**Consultation Response from KC,
Policy****2023/92448 Former Cooper Bridge Water Treatment Works, Leeds Road, Mirfield, WF14 0BT****Outline application for erection of B8 industrial unit****Date Responded: 26/06/2024****Responding Officer: HR****Responding Ref:**

This proposal is for the erection of a B8 industrial unit and associated parking located on the old waste water treatment works at Cooper Bridge. The application site is an employment allocation (ES9) on the adopted Kirklees Local Plan. The site is located in Flood Zone 2 and 3 (EA) and Flood Zone 2 and 3ai (SFRA).

SITE PLAN

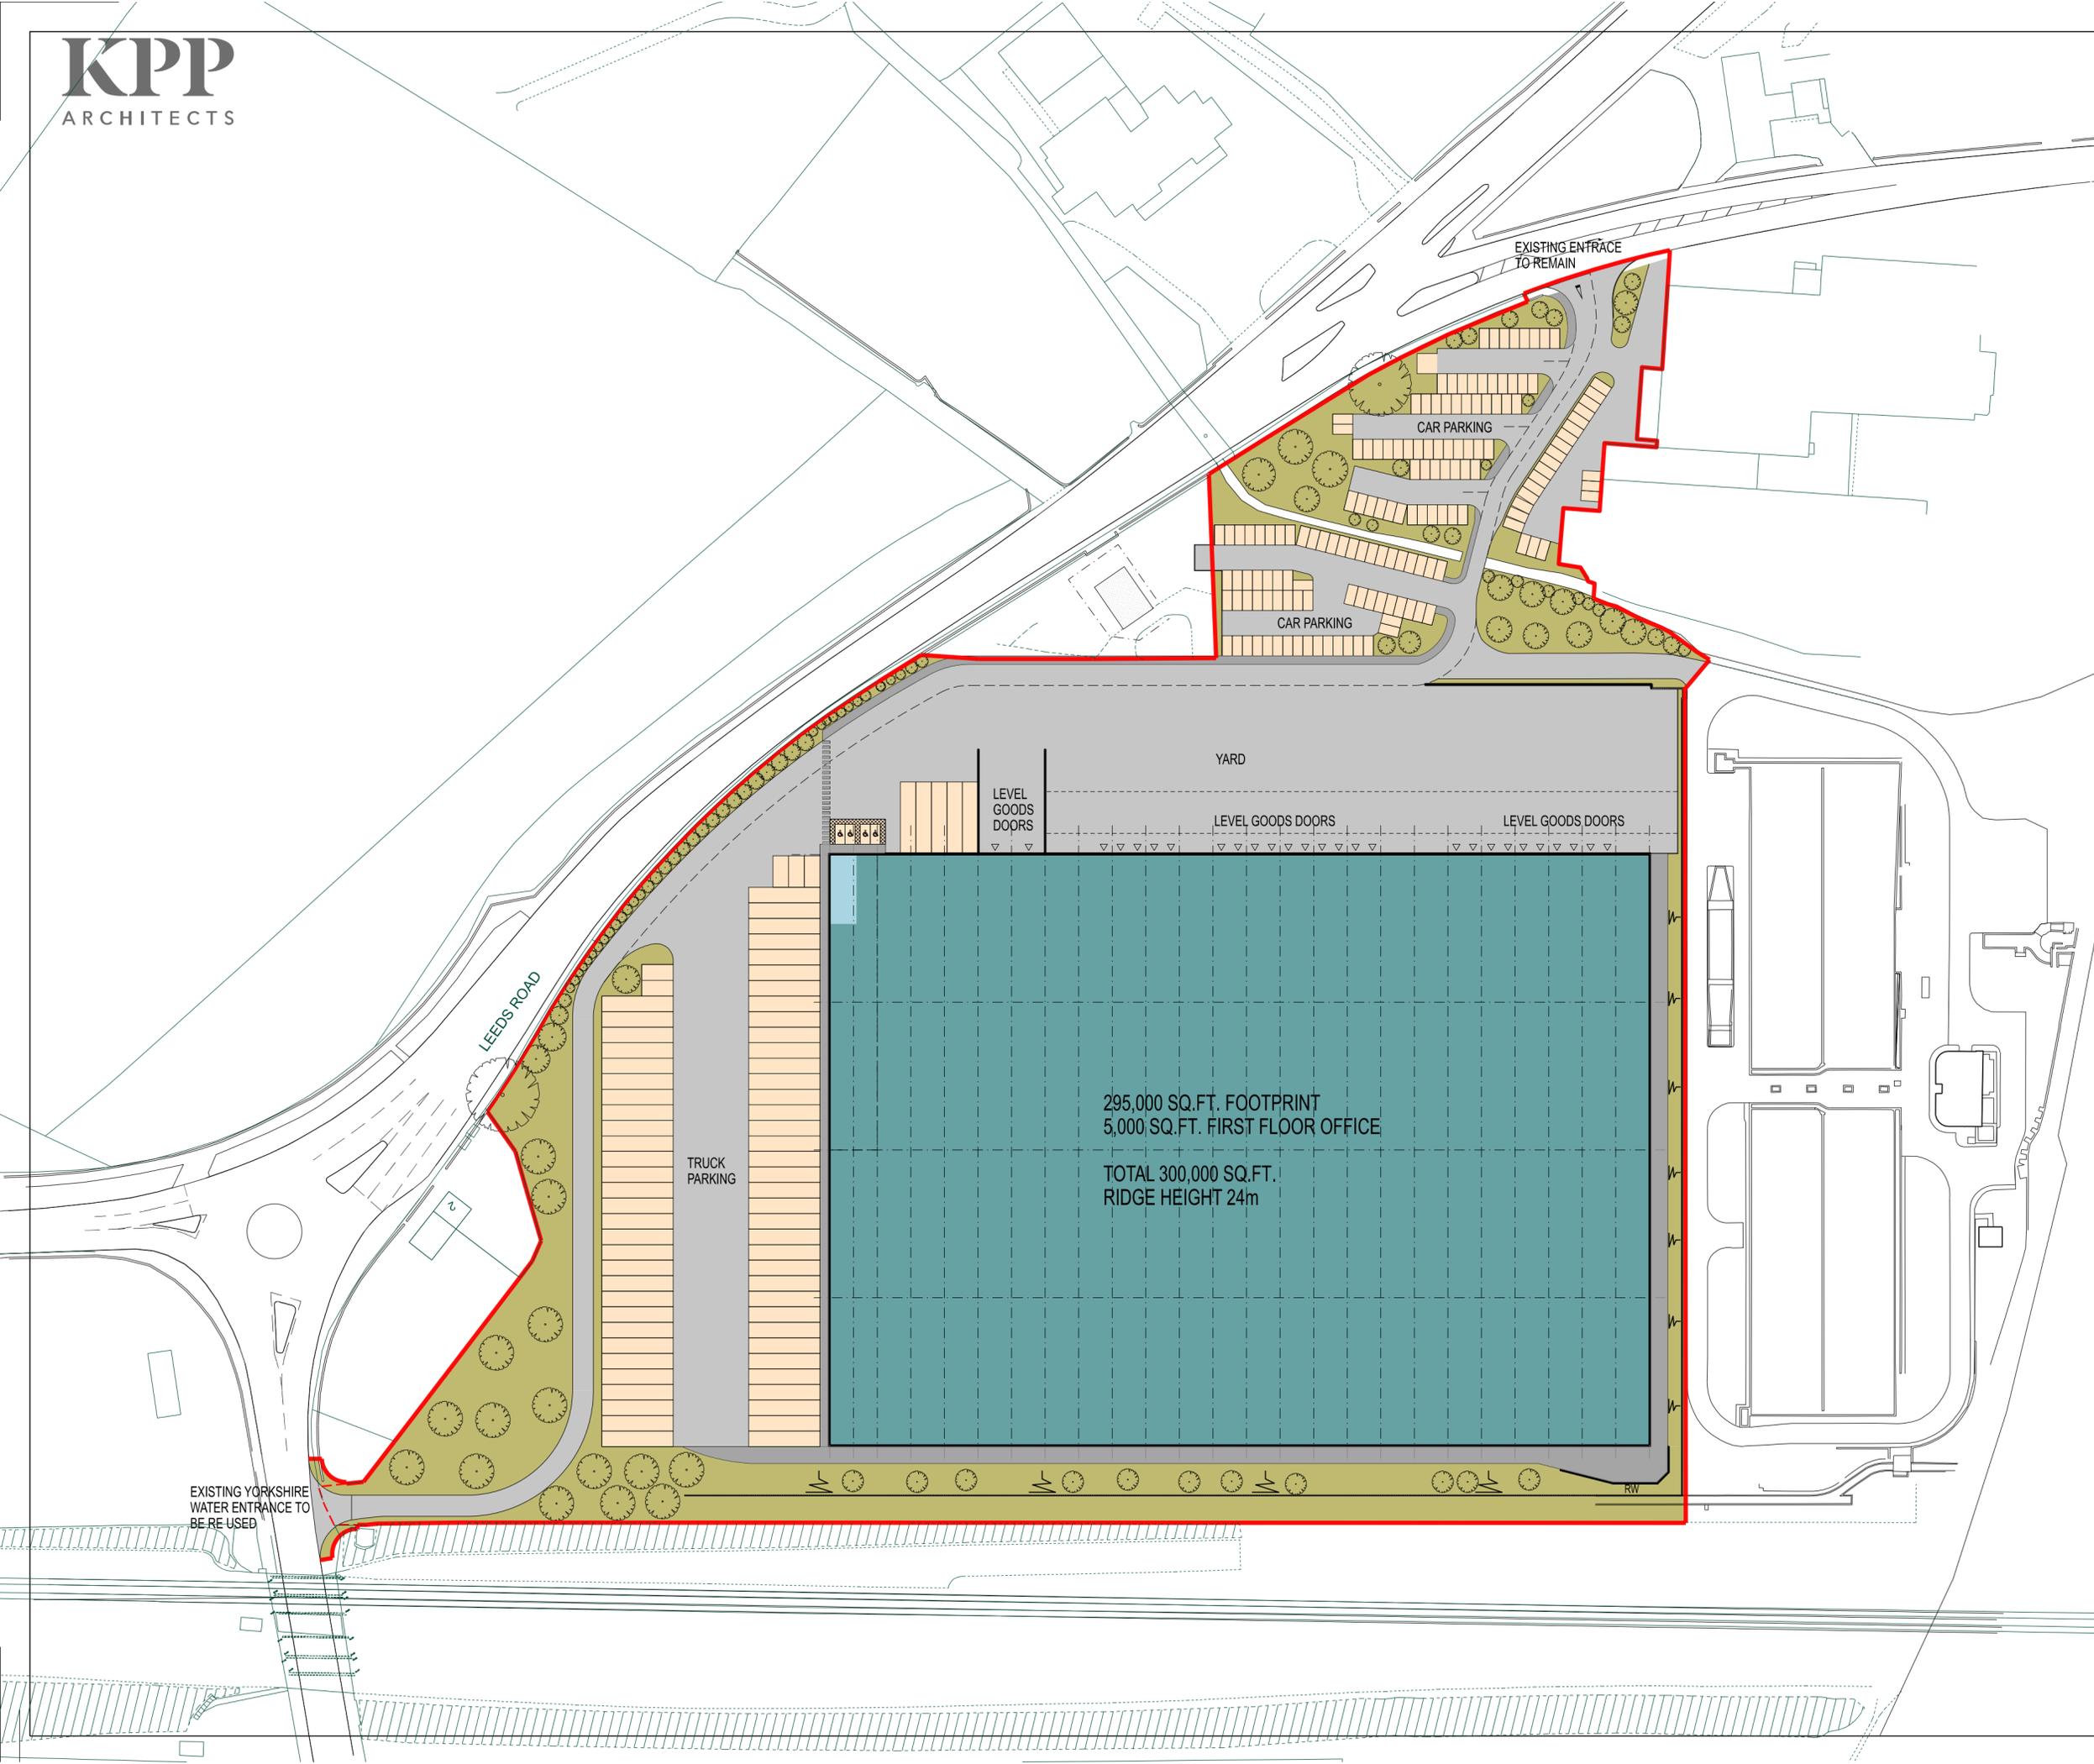
The whole site is located within flood zone 2 (EA and SFRA) with a proportion in the middle of the site in flood zone 3 (EA) and flood zone 3ai (SFRA) where there is a high probability of flooding. In relation to flood risk, general industry and car parking are a less vulnerable use as set out in the flood risk vulnerability classification, Annex 3 of the NPPF, therefore are appropriate, only after the sequential test has been passed (Table 2, NPPG). An exception test is not required in this case.

Employment allocation (ES9) was subject to a Sequential Test as part of the Local Plan process. As a result of this it was not the intention of the council at that time to develop areas of land within this allocation, located in flood zone 3ai. When allocating this site for development the council netted off the area of land located in flood zone 3ai and it was not included in the developable area of the site.

This application proposes to build on land located in flood zone 3ai therefore a Sequential Test will be required. Should the Sequential Test be passed the proposed building footprint must not exceed the footprint of the current developed area on the site.

A sequential test has not been submitted as part of this planning application, the following offers advice on how to carry out a sequential test.

- i. Where extensions are linked operationally to an existing business or,
- ii. Where redevelopment of a site provides buildings with the same or a smaller footprint.
